M^CLAREN TRAFFIC ENGINEERING

1 August 2017

LETTER RESPONSE TO DEPARTMENT OF PLANNING AND ENVIRONMENT WITH REGARD TO THE WOOLLOOWARE BAY TOWN CENTRE AT 471 CAPTAIN COOK DRIVE, WOOLLOOWARE

RETAIL ACCESS - LEVEL 1

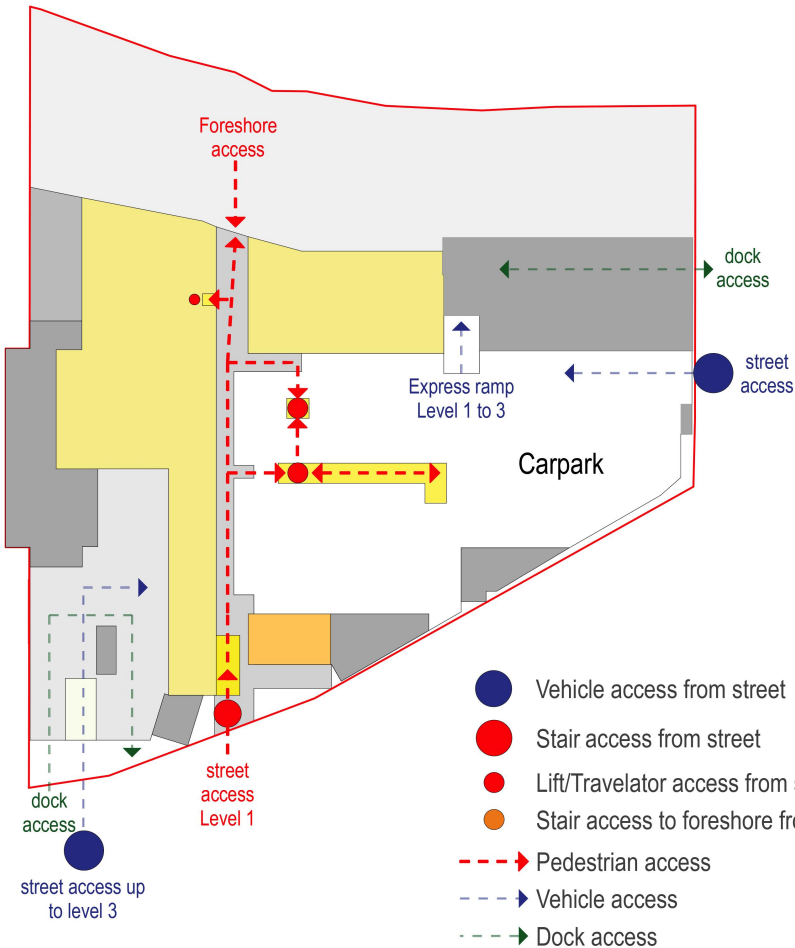
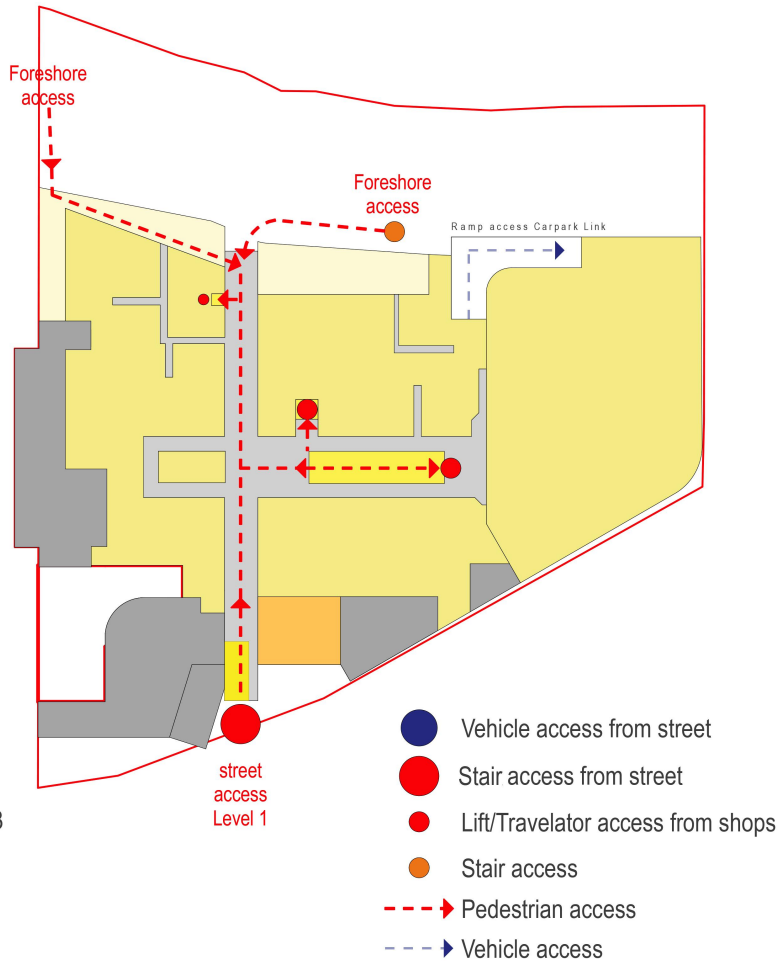
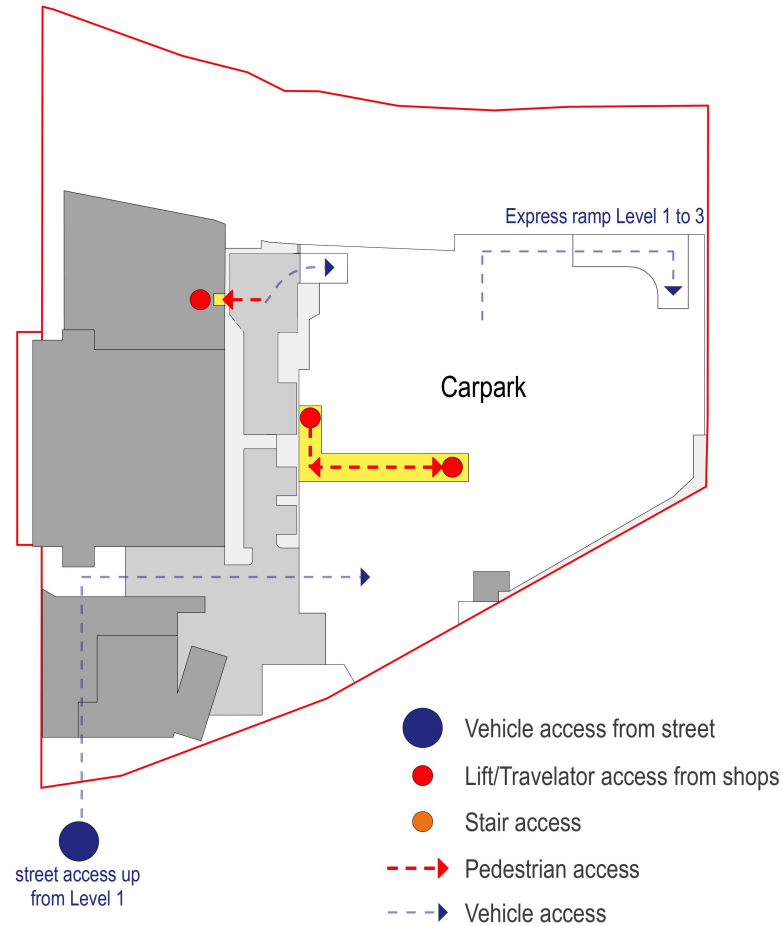
5. Further details on the management of access and parking for each of the land uses, including consideration on whether shared or separate access will be provided, ease of access for visitors and dispersion of traffic to minimise queuing on both arrival and exiting the site.

The increased vehicle numbers and movements as a result of the modification will likely require redesign of the exit driveway on Woollooware Road North as insufficient queuing distance is available.

Two separate access points are provided for the development, via a signalised intersection on Captain Cook Drive and via Woollooware Road (N). These access points have previously been assessed and approved as part of the original Concept Plan and Project Application. No changes are sought to the external configuration of these traffic signals/access points as part of MOD 2.

1.3.2.3 Operation of Retail/Club Car Park Entry Points

To facilitate efficient entry into the retail/club car park, a number-plate reader system will be implemented. The operation of this system does not require drivers to stop at a boom gate and has sufficient capacity for approximately 1250 vehicles per hour per entrance lane; a peak of approximately 590 vehicles per hour per entrance is expected. This equates to a 98th percentile queue length of 5 vehicles and a 50th percentile queue length of nil (0) vehicles (ie. under average operation there will be no vehicles queued at the number plate readers).

1.3.2.4 Operation of Retail/Club Car Park Exit Points

Each exit from the retail/club car park is provided with two barriers/payment terminals. Queue lengths have been calculated using a low-range estimate that 50% of the parking will be prepaid (at a ticket machine within the centre), resulting in an approximate 5-second delay and that 50% will be paid at the terminal, resulting in an approximate 10-second delay using contactless payment. This results in a 98th percentile queue of 6 cars and a 50th percentile queue of nil (0) cars.

The proposed parking entry/exit system includes a number plate reader system which significantly reduces the wait time for patrons entering and exiting the car park. With reference to the SSC comments regarding the potential for queueing of vehicles at the exit to Woollooware Road north, the following analysis has been undertaken:

Based on the assumption that 50% of the exiting vehicles will have prepaid their parking, corresponding to a five (5) second wait time, and that the remaining 50% will pay via contactless payment at the gate, corresponding to a ten (10) second wait time, each exit terminal has the capacity for some 480 vehicles per hour. This results in a total capacity for some 960 vehicles to exit each hour at the Woollooware Road north exit and 960 per hour at the L3 exit for a net capacity of 1920 vehicles per hour. The total traffic generation of land-uses that utilise this car park in peak times is approximately 1440 vehicles, constituted by approximately 770 trips IN and 770 trips OUT. Based on this, the 770 outgoing vehicles per hour, of which approximately half would use the Woollooware Road exit, will be able to exit without queues forming.

HOTEL &
SHARKS FACILITIES
LEVEL 3

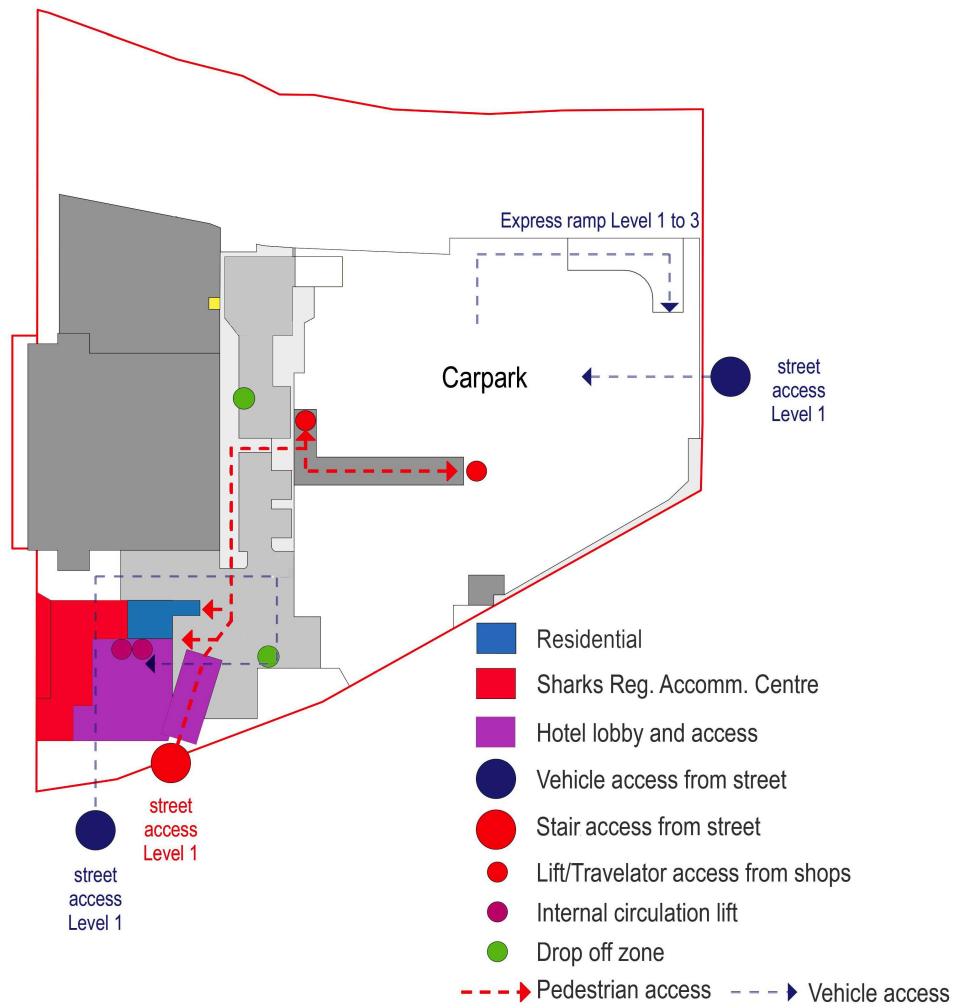
There may also be value in the hotel having access to its own parking spaces within the hotel building footprint accessed from the upper level internal road as a means of potentially increasing parking numbers, but more importantly making the arrival sequence simpler for visitors.

The hotel has been provided with a separate parking area accessible from the Level 3 roadway, such that visitors can easily park their vehicle upon arrival at the hotel.
